Our Ref: BR/320/18/PL
Your Ref:

Town & Country Planning Act 1990 (as amended)
Town and Country Planning (Development Management Procedure) (England) Order 2015
Application for Planning Permission

Development Two storey side extension to form 2 No. self contained flats, replacement of ground floor front window with bay window, flat roof canopy to side elevation, porch extension to rear elevation, first floor balcony & insertion of flush fitting sun pipe. This application affects the character & appearance of The Steyne Conservation Area.

Location 9B Waterloo Square Bognor Regis

PROPOSED ELEVATIONS

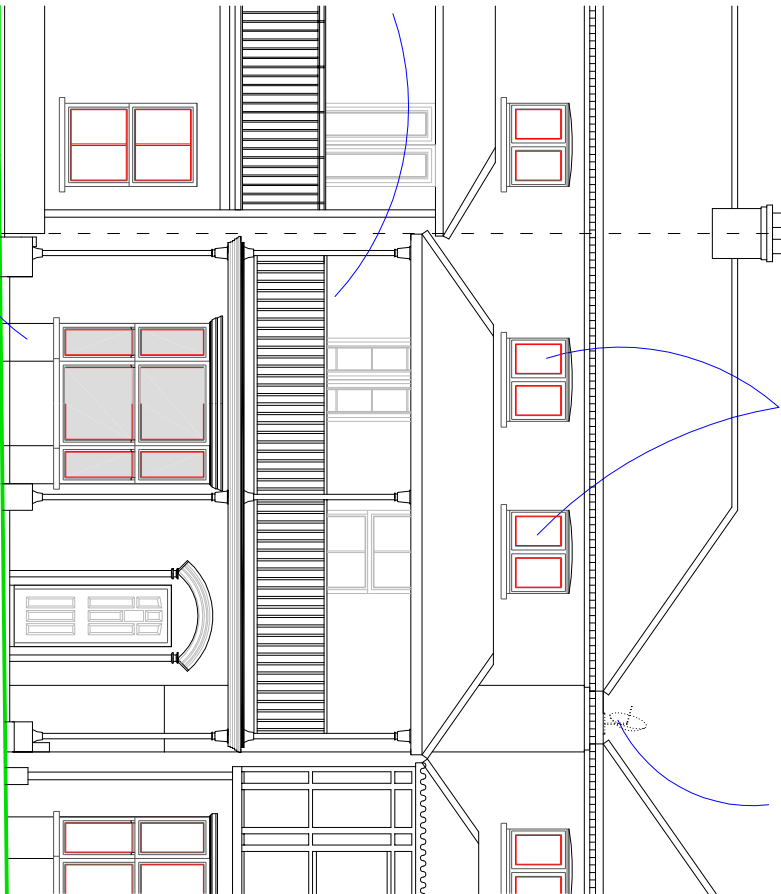
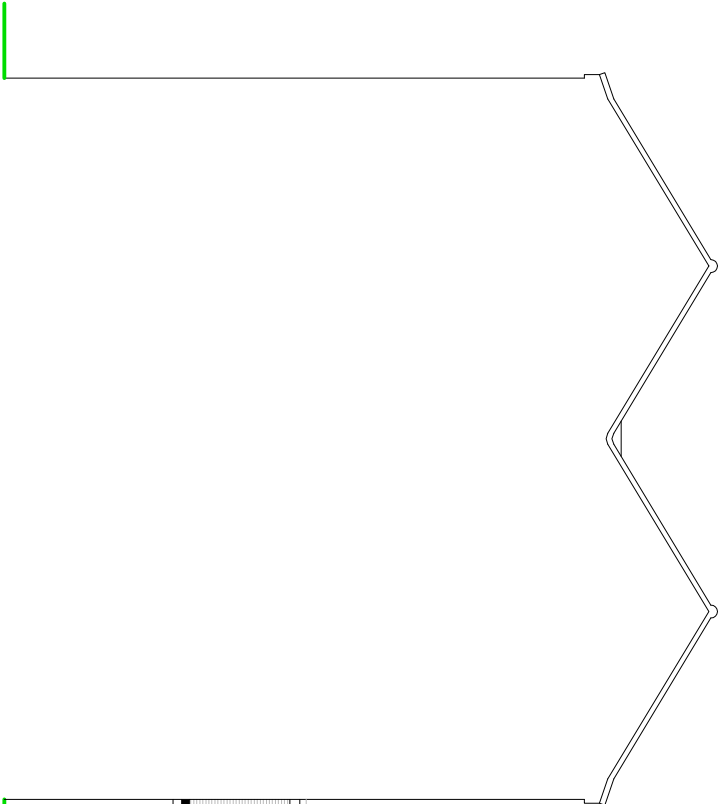
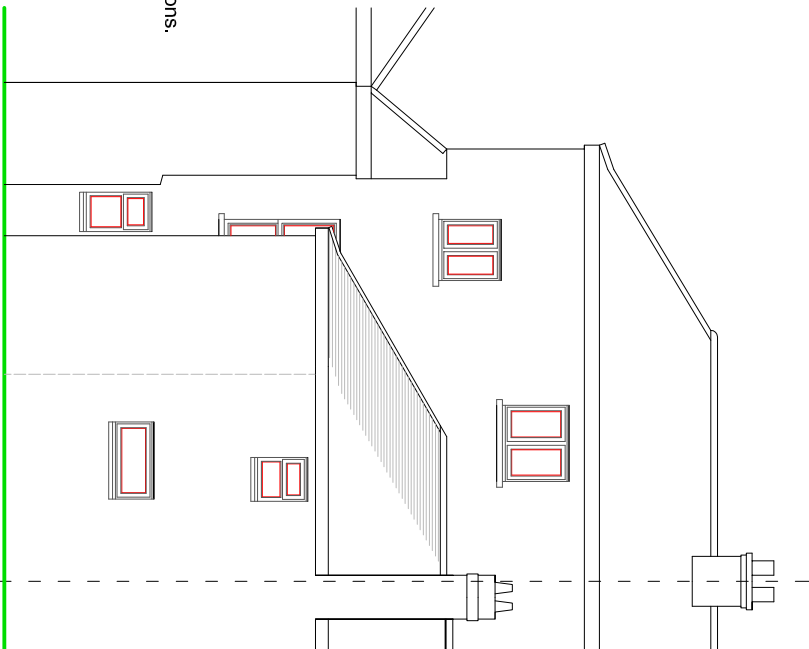
The existing and proposed first floors and front elevations do not accord. Please amend accordingly.

The proposed first floor plan and rear elevation do not accord. Please amend accordingly.
